To: Clyde Blackwell **From:** Mike Nugent

Fax: 842-6271 **Date:** December 15, 2003

Re: 1200 Congress St. (189 A013)

I have reviewed the submissions for Permit #031478 and have the following questions/comments:

drawing title  
**First and Second Floor Plans  
Door Schedule**

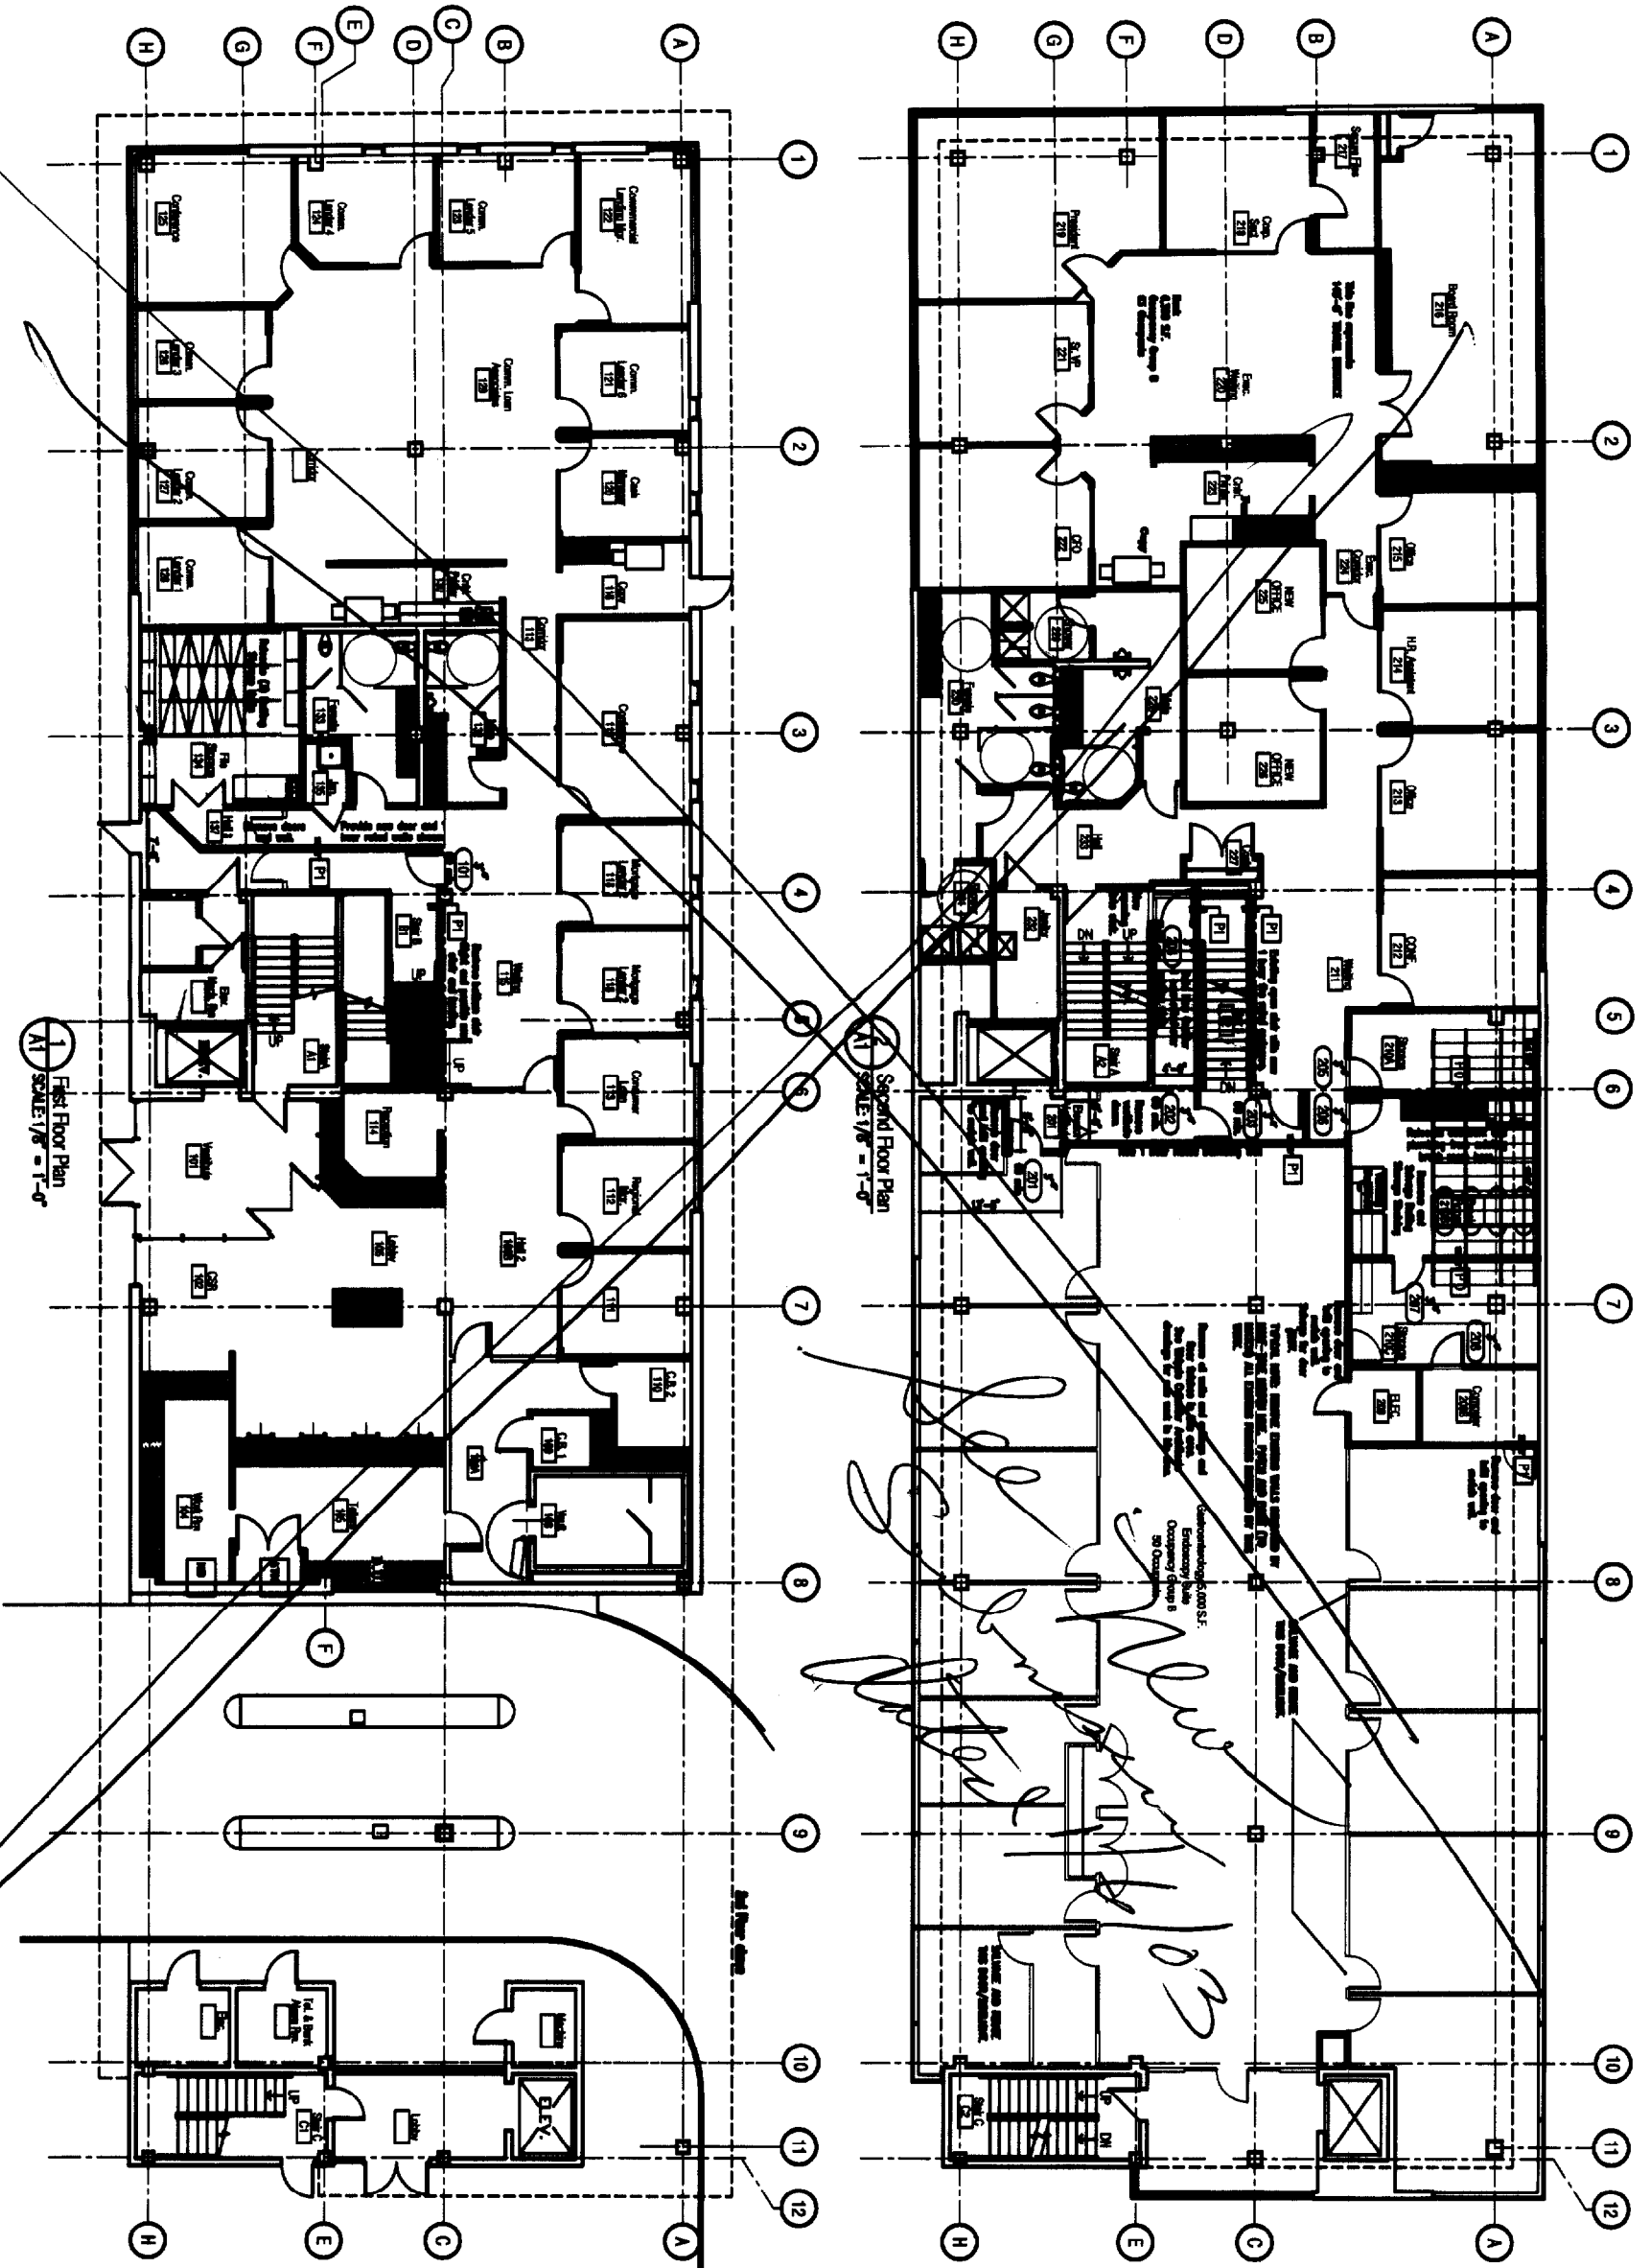
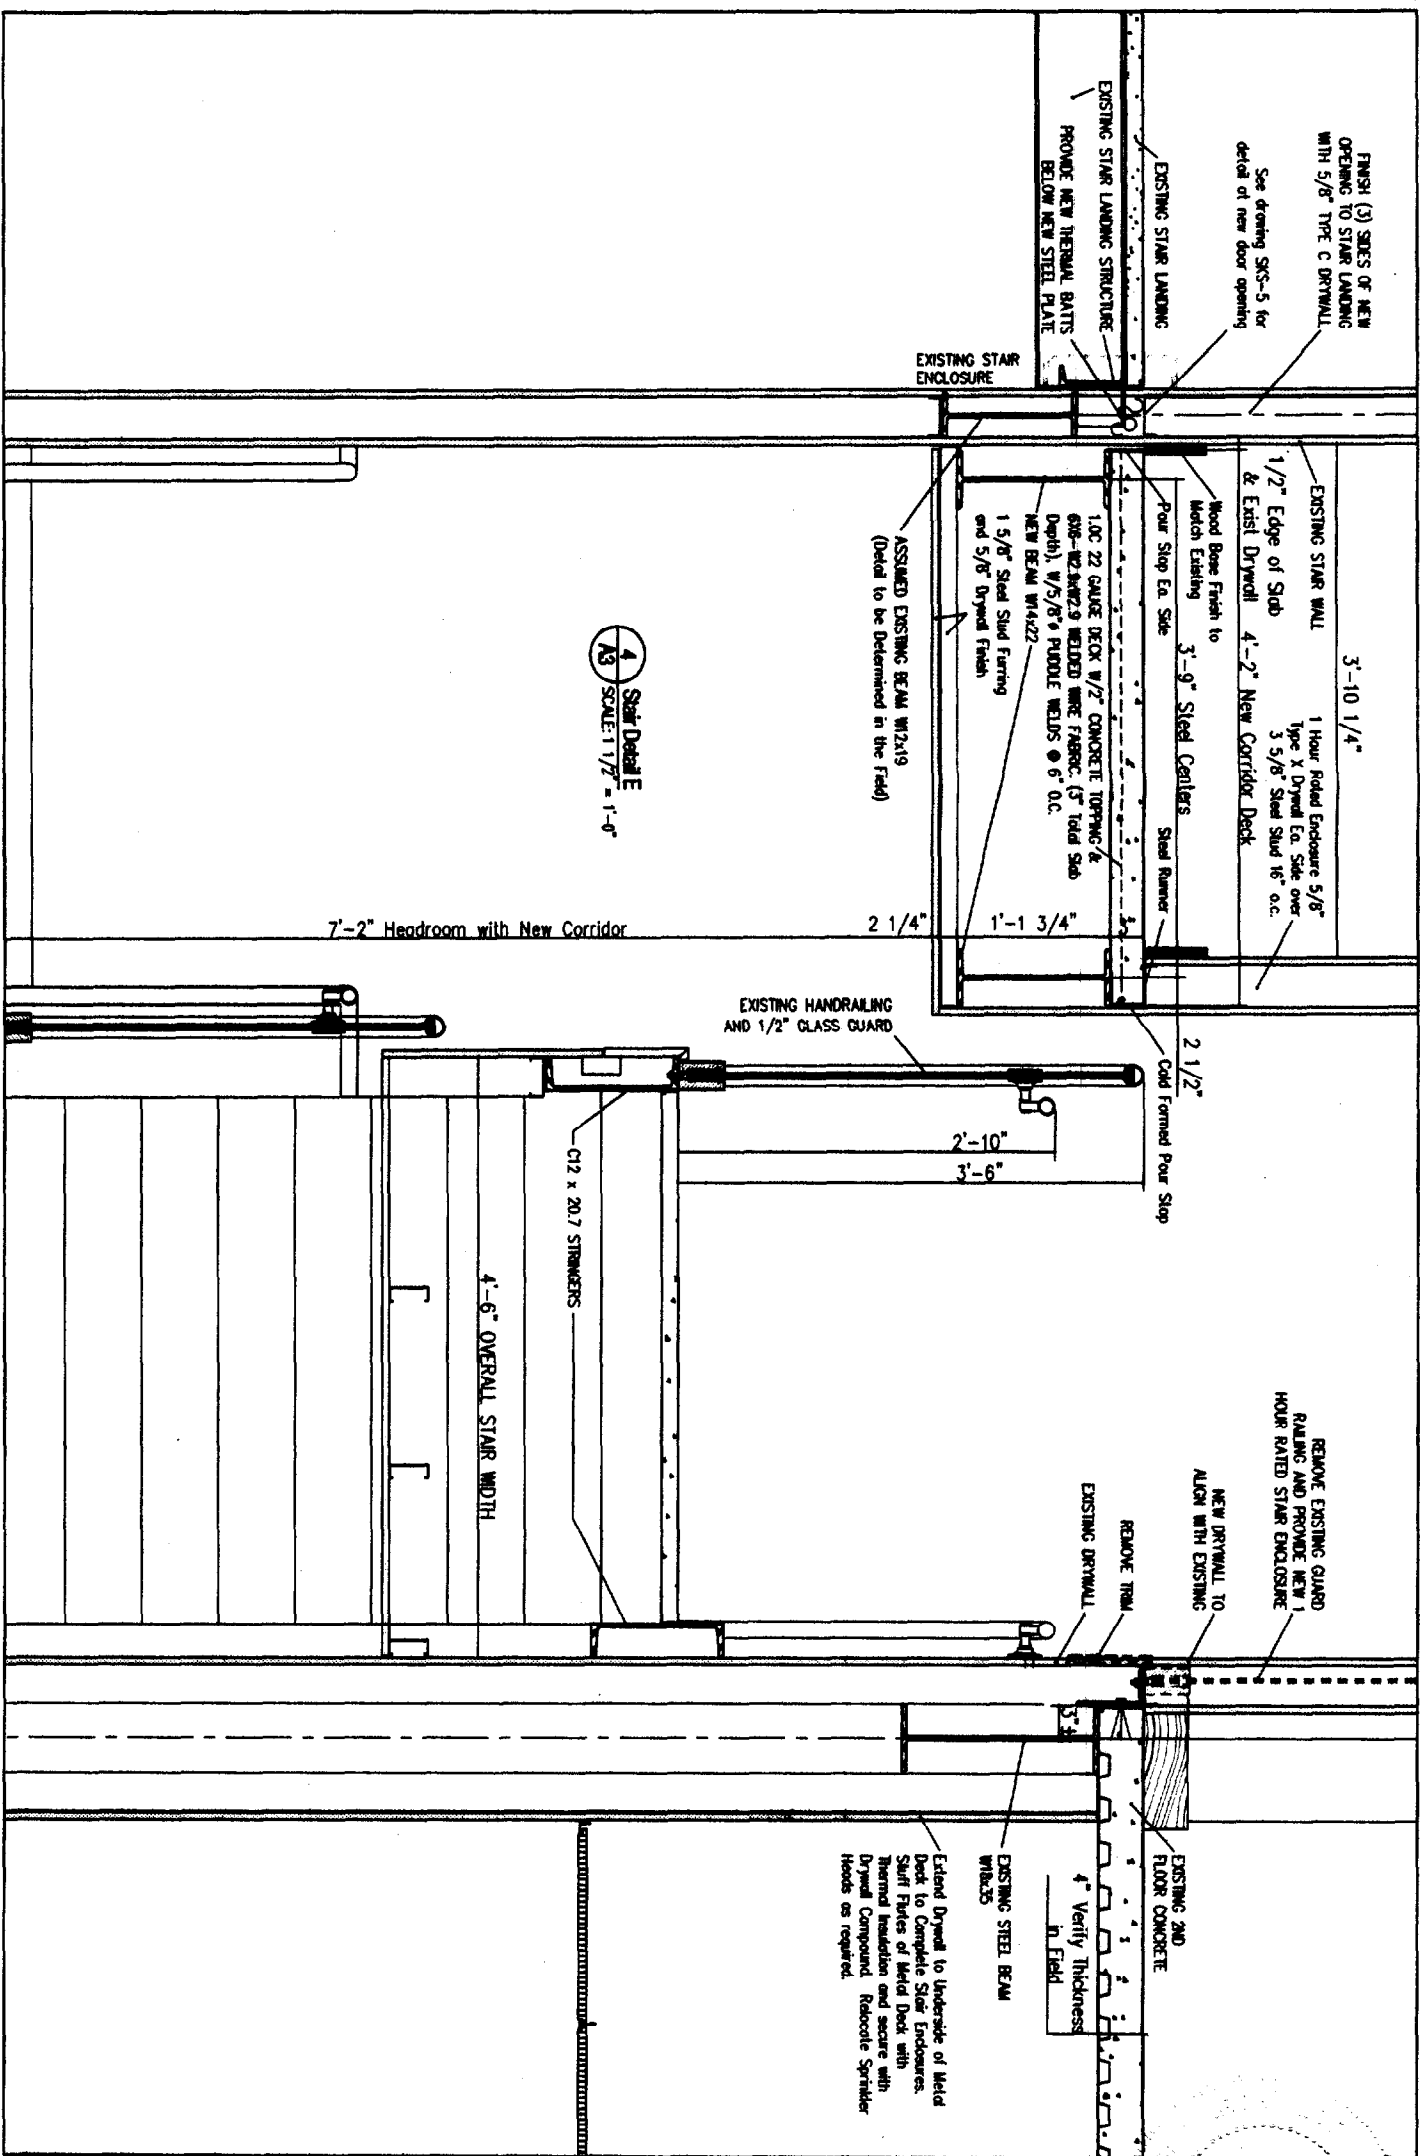
- 1) The construction drawings are not stamped.
- 2) Is the exit corridor on the first floor (fig. 1/A1) at least 44 inches in width?
- 3) A statement of special inspections is required for the new steel/concrete and fasteners. (See Section 1705 of the 1999 BOCA Code).
- 4) Tread and riser dimensions for new stairs?
- 5) Floor loads for new systems
- 6) Are the openings in the Guard shown on Fig. A-A2 Less than 4 inches with an ornamental pattern that is not a ladder.
